Re: Objection to MP08_0244 MOD 1 Modification Request for Mixed Used Development at 23-37 Lindfield Avenue and 11 Havilah Lane, Lindfield

Major Projects Assessment
Department of Planning and Infrastructure
GPO Box 39, SYDNEY, NSW 2001

ELEVATIONS

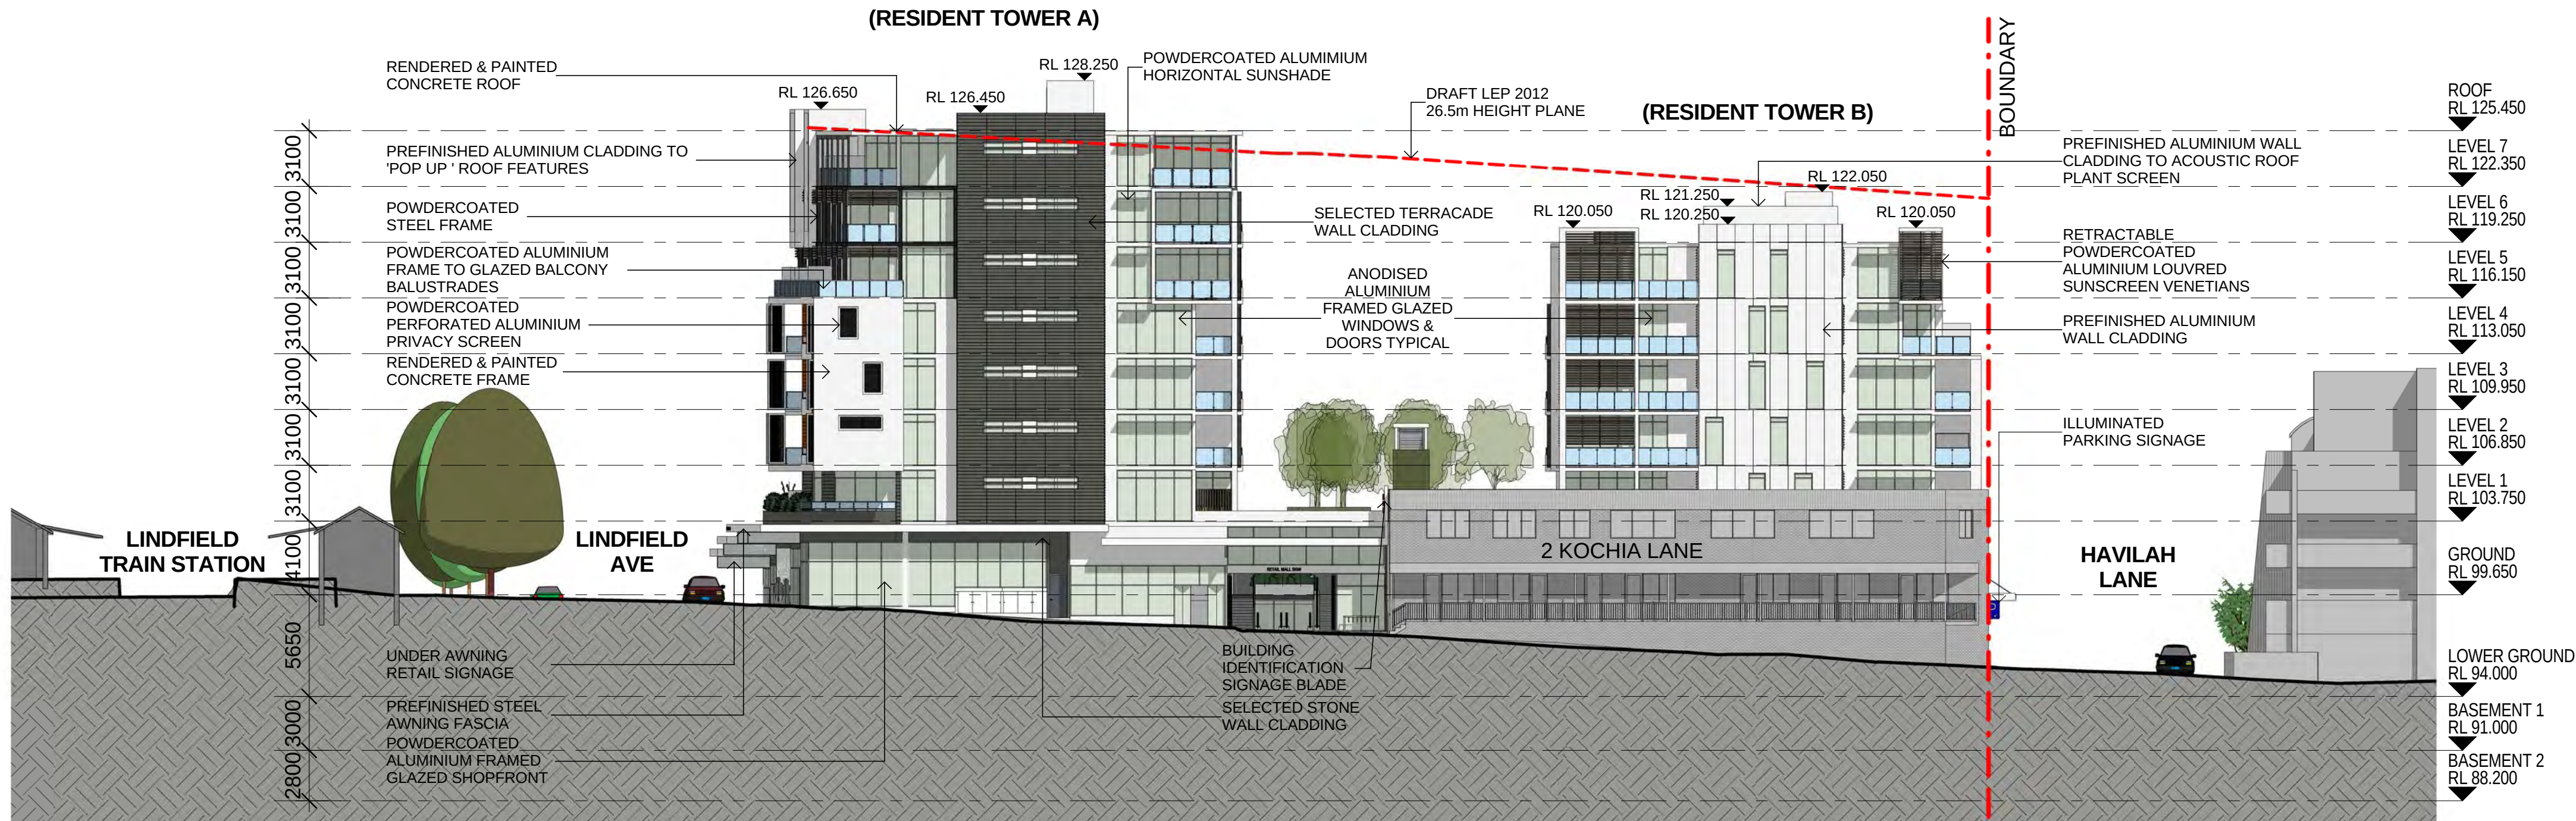
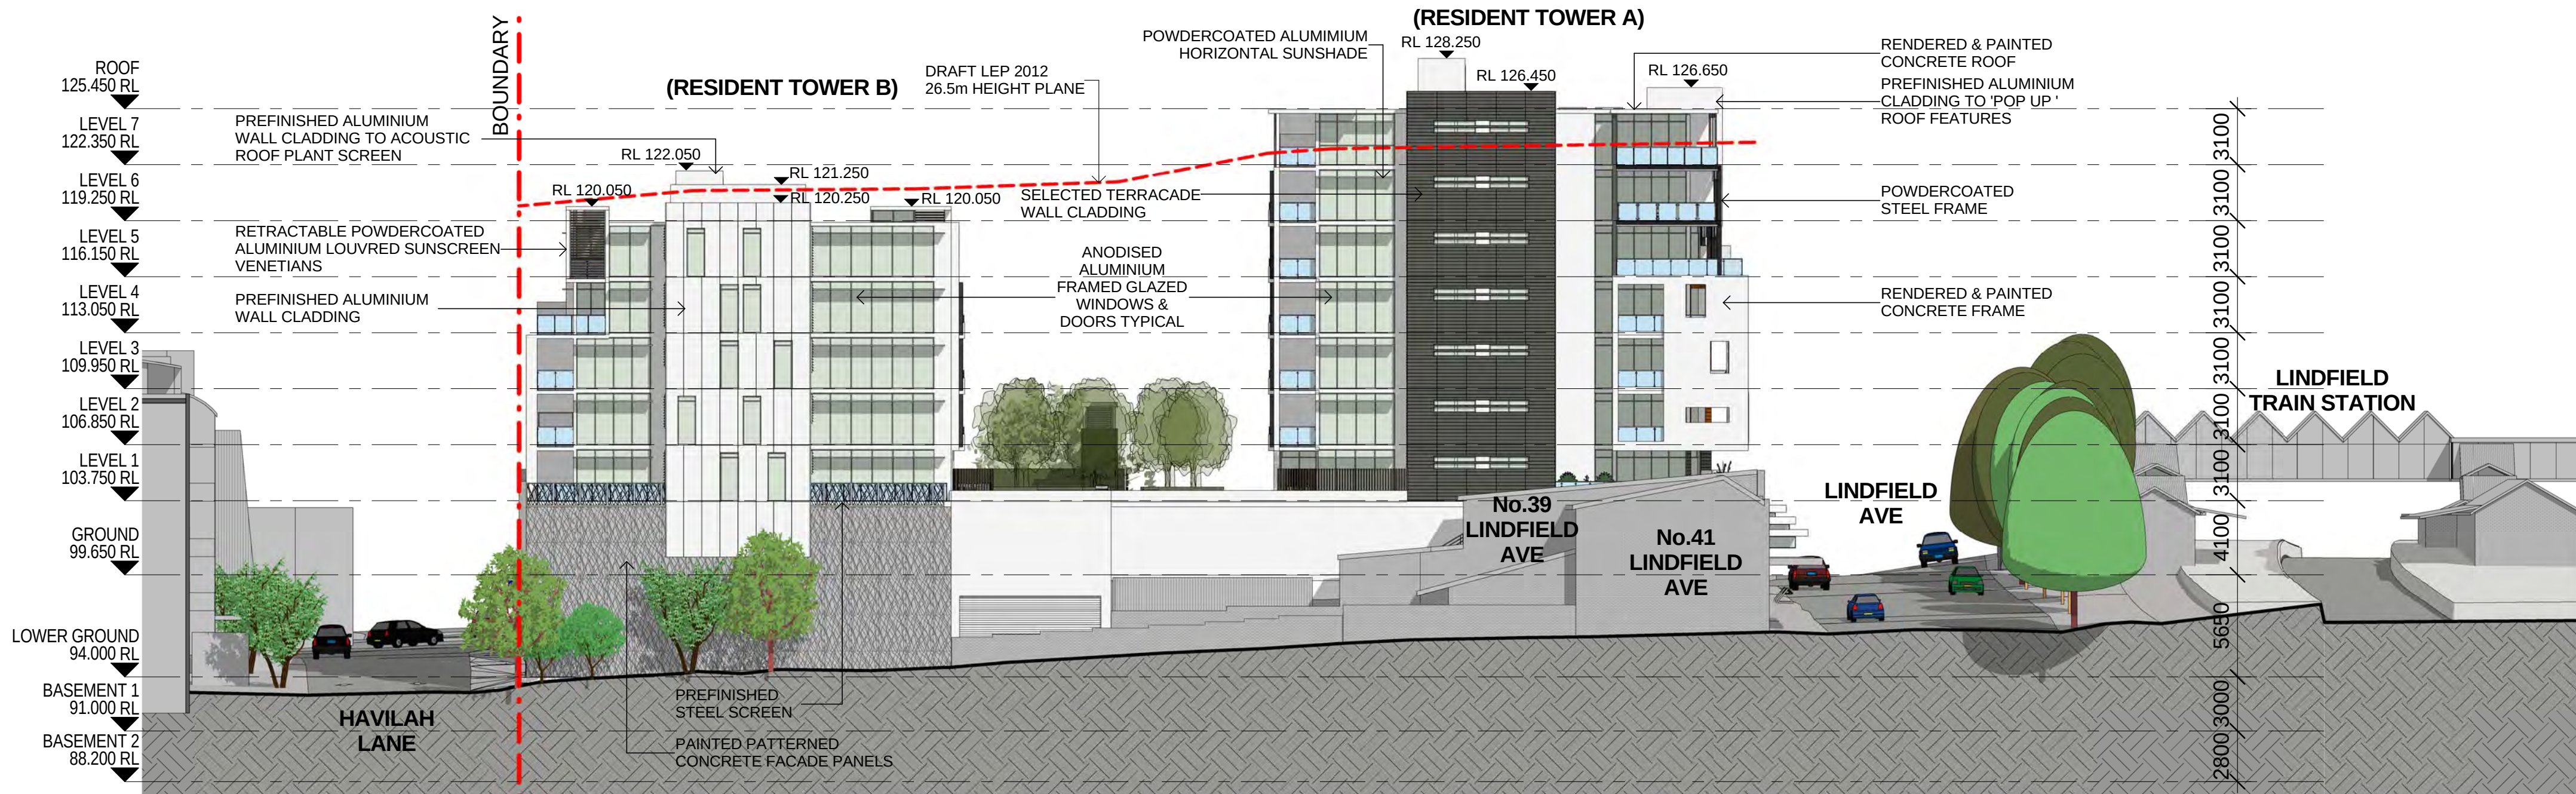
- The increase of an additional storey to both buildings: 8 storeys on Lindfield Avenue and 7 storeys on Havilah Lane creates excessive height and bulk and is out of character with the surrounding buildings, including the heritage listed adjacent building on Lindfield Avenue

- The additional storey (combined with less set back than the approved design) on Havilah Lane now creates privacy concerns for over 40 apartments in the adjacent 8 Havilah Lane, 8 Kochia Lane and 2-8 Milray Street residences
